**From:** Iain Osenton <iain.osenton@cherwell-dc.gov.uk>  
**Sent:** 08 June 2021 16:01  
**To:** Planning <Planning@Cherwell-DC.gov.uk>; dcregistration <dcregistration@Cherwell-DC.gov.uk>  
**Cc:** David Lowin <David.Lowin@Cherwell-DC.gov.uk>  
**Subject:** 21/01454/F - CDC Arboriculture.

From desk based assessment.  
Comment – Objection.

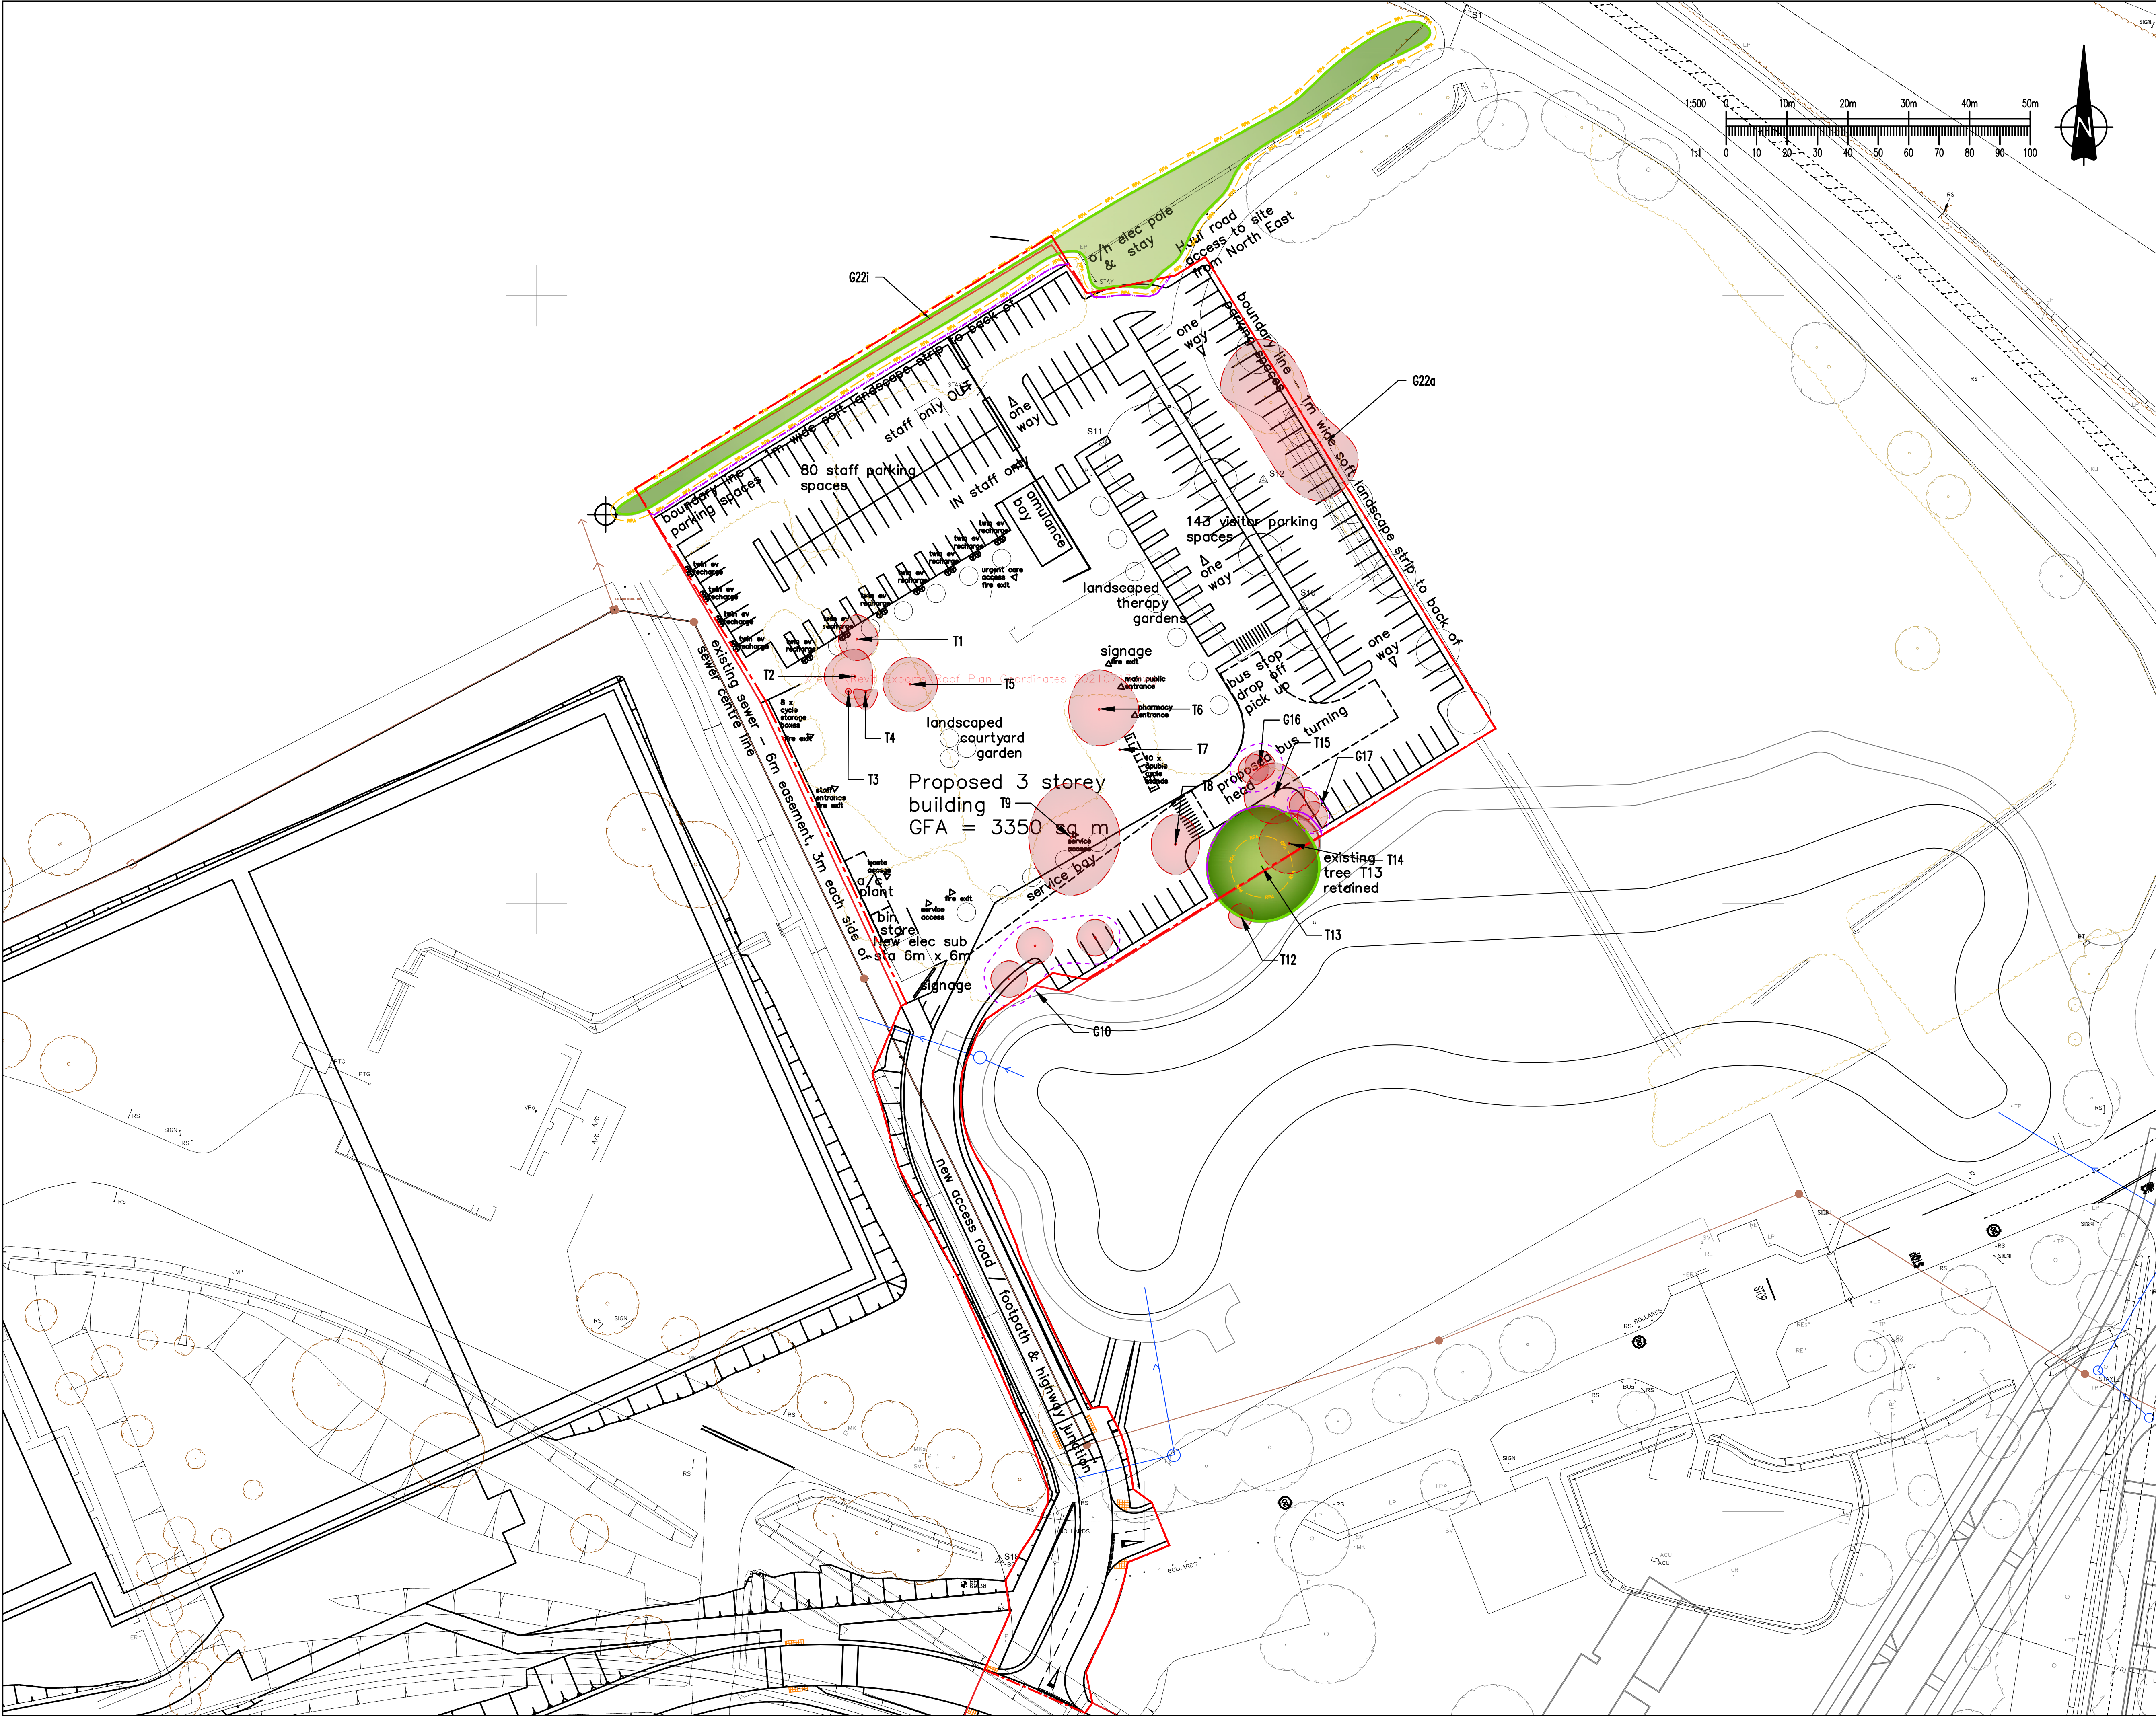
The addition of hard surfaces beneath the crown spread of T13 appears to abut the RPA, I expect fibrous roots will be present on the RPA boundary. With that, not only does the implementation of hard surfacing hold potential to damage fibrous roots, but the hard surfacing could be expected to conflict with future root growth. There are no details submitted of arboricultural supervision for root pruning. Furthermore, Car parking beneath T13 is inappropriate, as Quercus spp. drop hard fruits, vehicle damage could be expected.

Table 3 recommends crown lifting T13 by 3m as mitigation for potential vehicle damage. The area beneath T13 according to drawing 2 is to be used as a bus turning area, suggesting a 3m lift will not offer appropriate clearance. A crown lift of 5m could therefore be expected, reducing the likelihood of successful balancing pruning on the opposing side(s) and negatively impacting T13s amenity.

T13 being (pending T14) the only single, mature retained feature within the site requires greater consideration within the proposal. The proximity of hard surfacing to the RPA and crown spread creates both immediate, and long term conflict, contrary to BS5837:2012 guidance. I believe in order to address this, the following options need to be considered:

- Removal of parking bays beneath T13s crown spread (anticipating short term branch growth)
- Widening of soft landscaping area to reduce implementation impact to roots.
- Widening of soft landscaping area to account for future root growth. Currently, long term restriction of root development, and direct damage to hard surfaces could be expected.
- Adjustment of bus turning area location to avoid above ground conflict with T13.
